# CITY OF ALBUQUERQUE

October 30, 2015

RE: **Shawn McWethy Park**  
**Grading and Drainage Plan**  
**Grading Permit / Paving Permit**  
**Engineer's Stamp Date 10/19/2015 (File: J09D023A)**

1 SWALE SECTION A-A CAPACITY

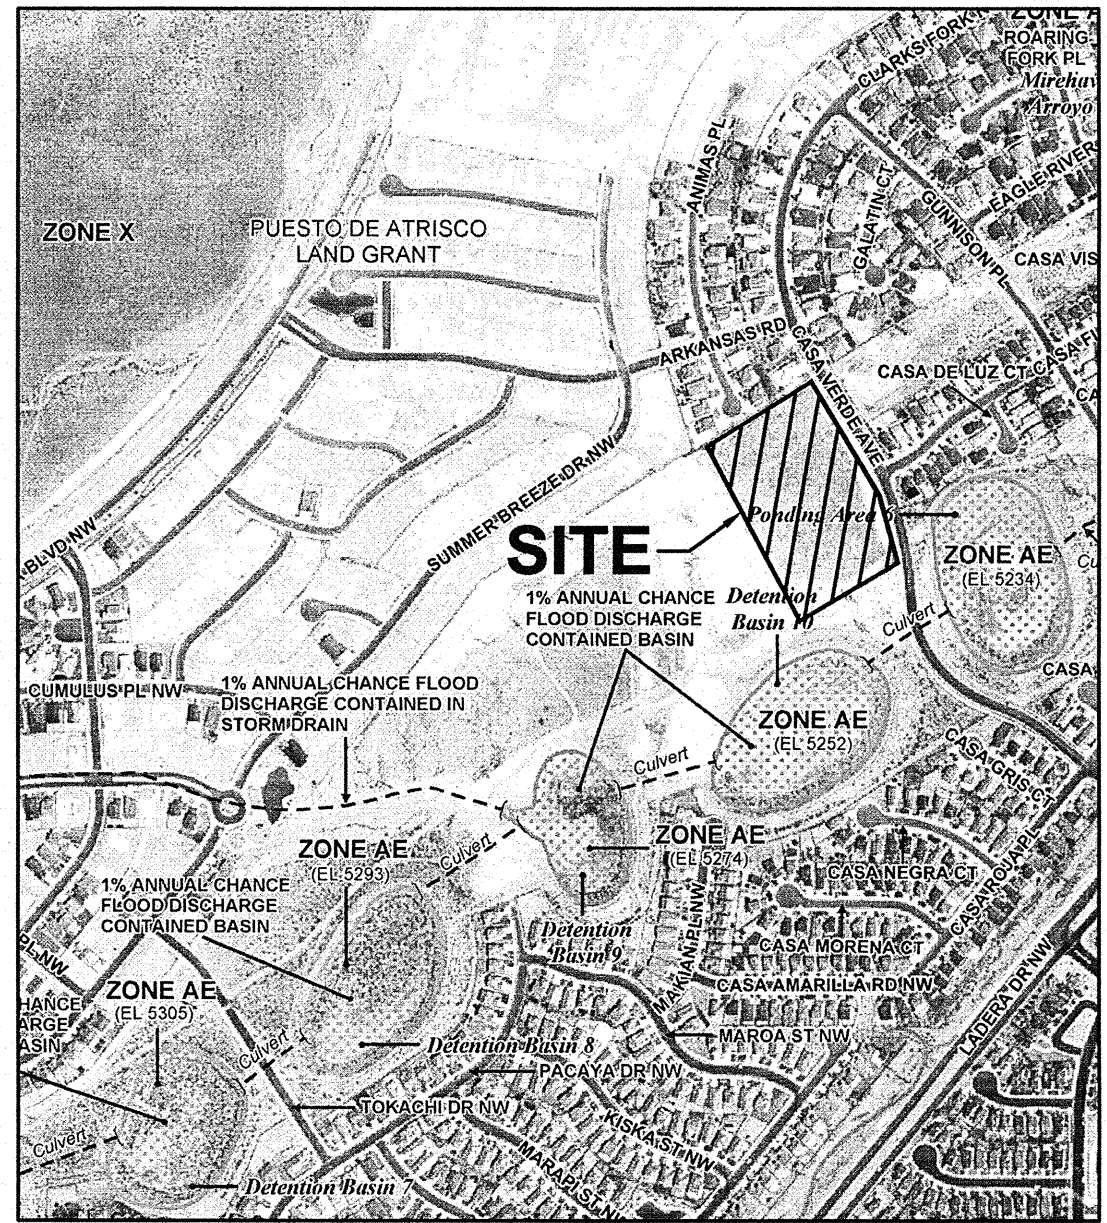
- Provide an excerpt from the approved Drainage Masterplan referenced (cover, table of contents and applicable section), which allows the peak discharge of 15.07 cfs from the site.
- Provide a capacity calculation for the swale along the north edge of the property.
- Provide a capacity calculation for the rundown from Basin 7.
- Clarify how the first flush from the parking lot enters the water quality pond.
